**KIRKLEES METROPOLITAN COUNCIL  
INVESTMENT & REGENERATION SERVICE**

Reference No:	<b>2025/44/91747/W</b>
Site Address:	Bolster Moor Coffee Shop, 1A, Bolstermoor Road, Bolster Moor, Huddersfield, HD7 4JU
Description:	Discharge of details reserved by conditions 2 (landscaping scheme) and 3 (parking scheme) of previous permission 2024/93556 for change of use of land and creation of customer car park
Recommending Officer:	Joanna Rednall

**DECISION – DISCHARGE OF CONDITIONS APPROVED**

## **Officer Report**

Site plan (1:500)

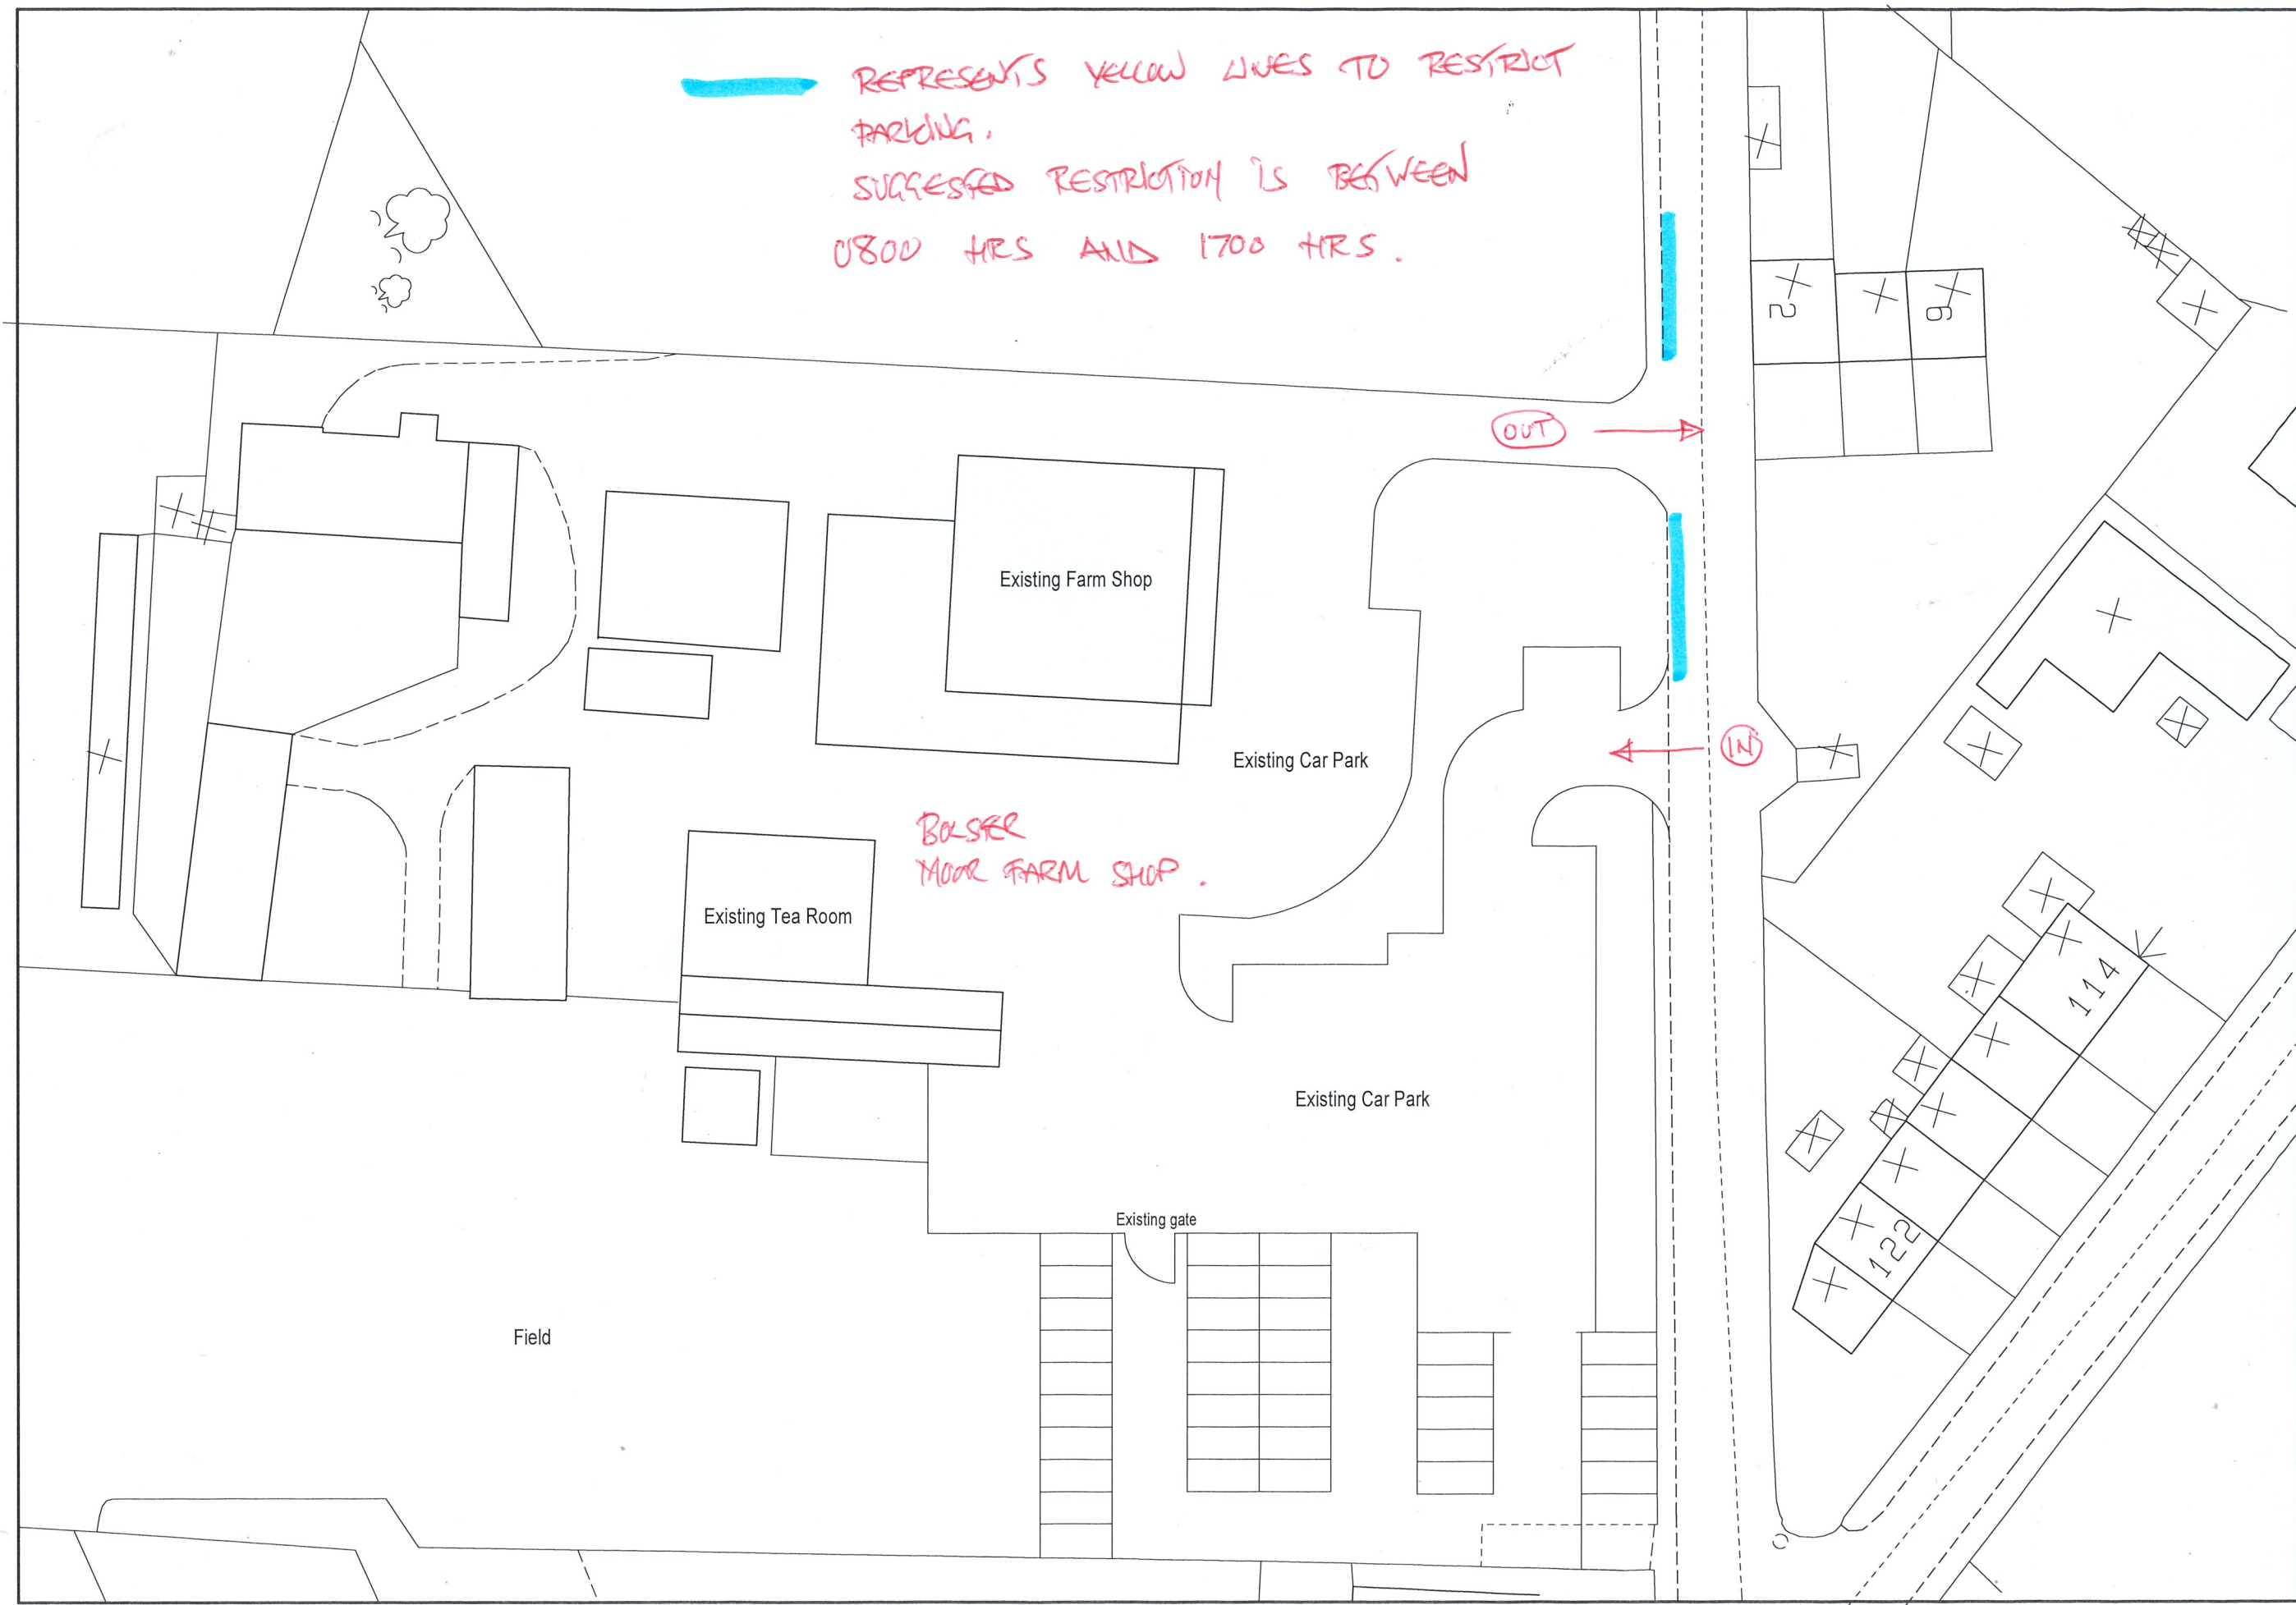
The KC Highways Development consultation response dated 21 July recommended formal waiting restrictions, implemented via a Traffic Regulation Order, to provide double yellow lines at the site access. In response, the applicants have submitted a Site Plan dated 12 September 2025 showing proposed waiting restrictions at the site access between 08:00 and 17:00. The Highway Safety Section has reviewed this proposal and confirmed that the extent of the proposed waiting restrictions is acceptable. HDM has raised no objection to the discharge of the first part of this condition.

For information, Highway Safety advises that the restrictions should ideally be “no waiting at any time,” as residents currently rely on these stretches for parking. Double yellow lines would therefore be preferable to single yellow lines with a time plate.

A separate process would need to be undertaken (traffic regulation order) which ensures this is undertaken. For the purposes of setting out a scheme considered acceptable by the Highways Team, this is considered to be met by the submitted scheme and it is therefore recommended the condition is discharged on this basis.

The details provide are considered to be sufficient information and an acceptable scheme to enable the discharge of Condition 3. It is a requirement of this condition that the development be carried out in accordance with the submitted scheme.
